From: [Nigel Stringer](#)
To: [East Pye Solar](#)
Cc: [REDACTED]
Subject: water supply
Date: 30 September 2026 10:05:36
Attachments: Screenshot 2026-09-30 at 09.03.27.png

IPR No: [REDACTED]

Response required: To confirm water supply as stated.

Site Location Plan: Site 5

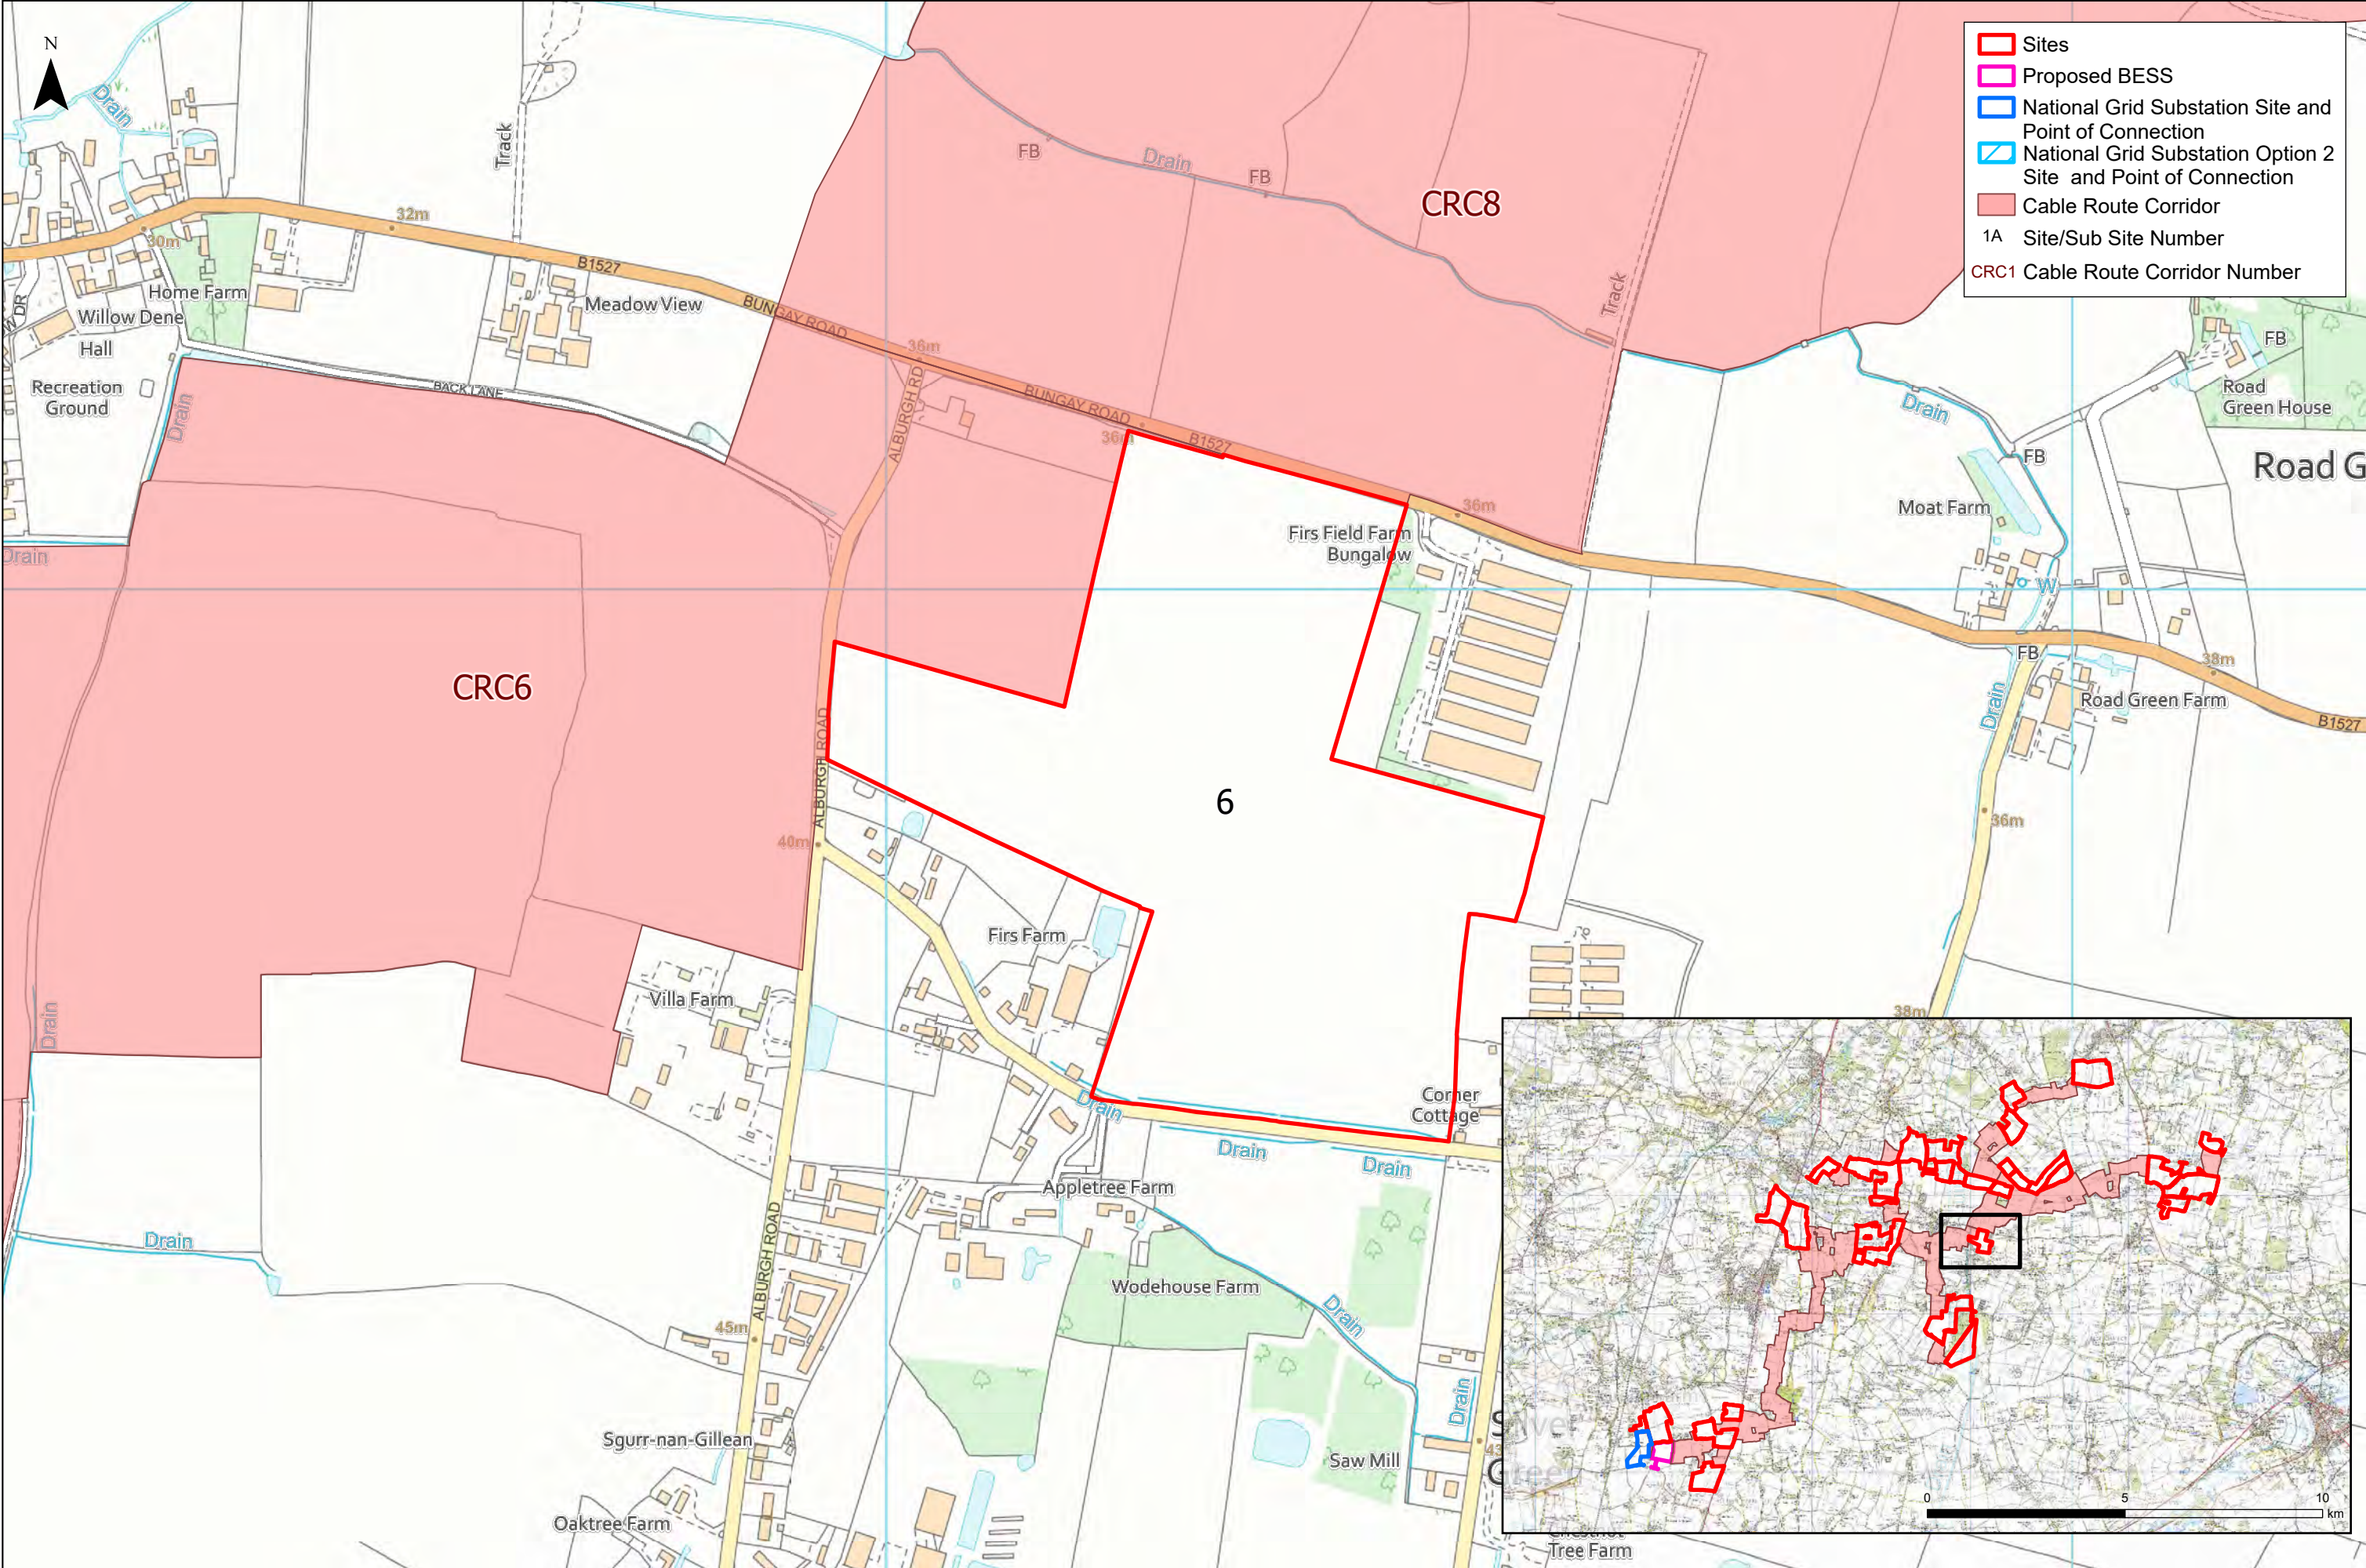
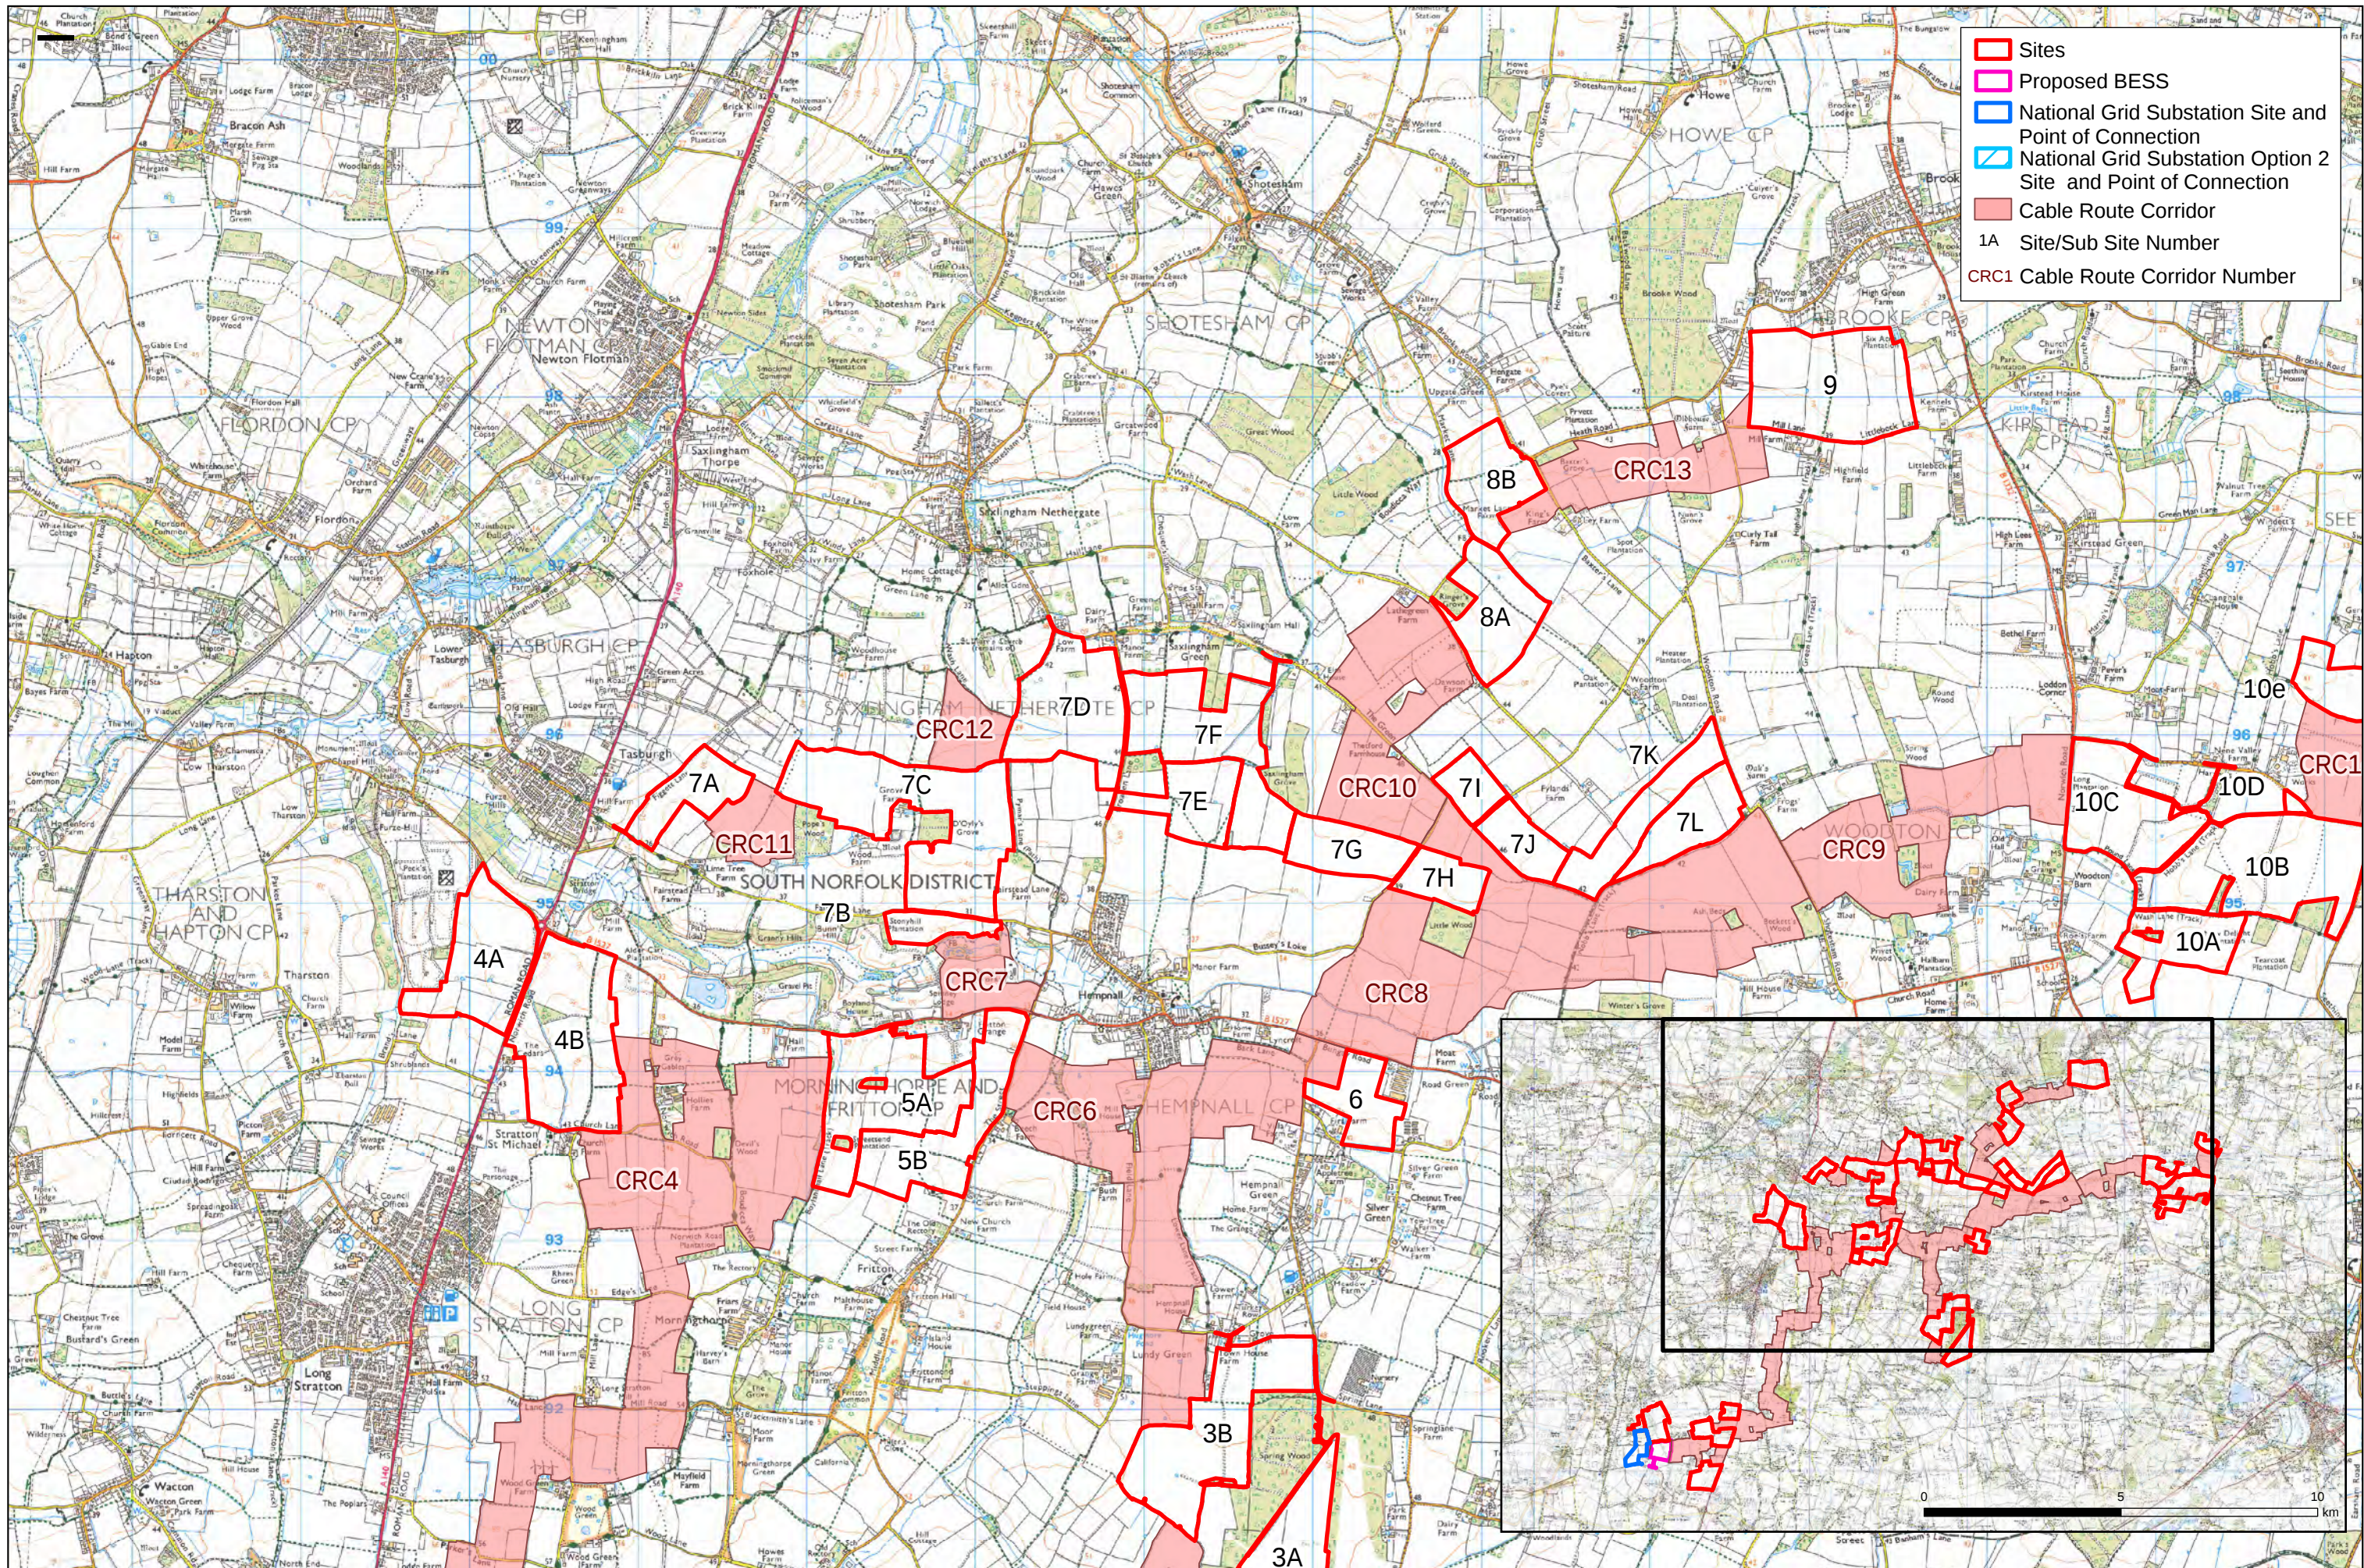
Please see attached Google map plan of site affected. The water supply to our property is a spring fed well at the rear of the house where the well pump feeds water from the ground supply to the house. The supply level water depth is between 1m and 2.5m below ground level depending on the season. It is our only water supply, we have no mains connection. Without it, we cannot live there.

Furthermore there is an ancient drainage tunnel through our grounds to the west of the house which drains water from the fields to the south of our property (Site 5) with further access points as it crosses our land and continues into the meadows to discharge onto the low lying land, the very point from where our well is fed. Any contamination of that drainage system will leach into the meadows and hence affect our well water. The water run off from site 5 will flow directly to that drain and across our land to the meadows, adjacent to our supply.

I put the Inspectorate on notice that this will be an ongoing and obvious health risk to anyone living in Boyland Hall. I have notified East Pye of this and have had no response. To avoid the possibility of any understatement or misunderstanding I state again: The proposal incurs an ongoing risk of contamination / poison to our water supply which is obvious. The water run off from Site 5 will include residue from construction activities and ongoing maintenance for the foreseeable future, eg washing of solar panels. The slope of the landscape dictates that all of that water will drain into the tunnel and across our land.
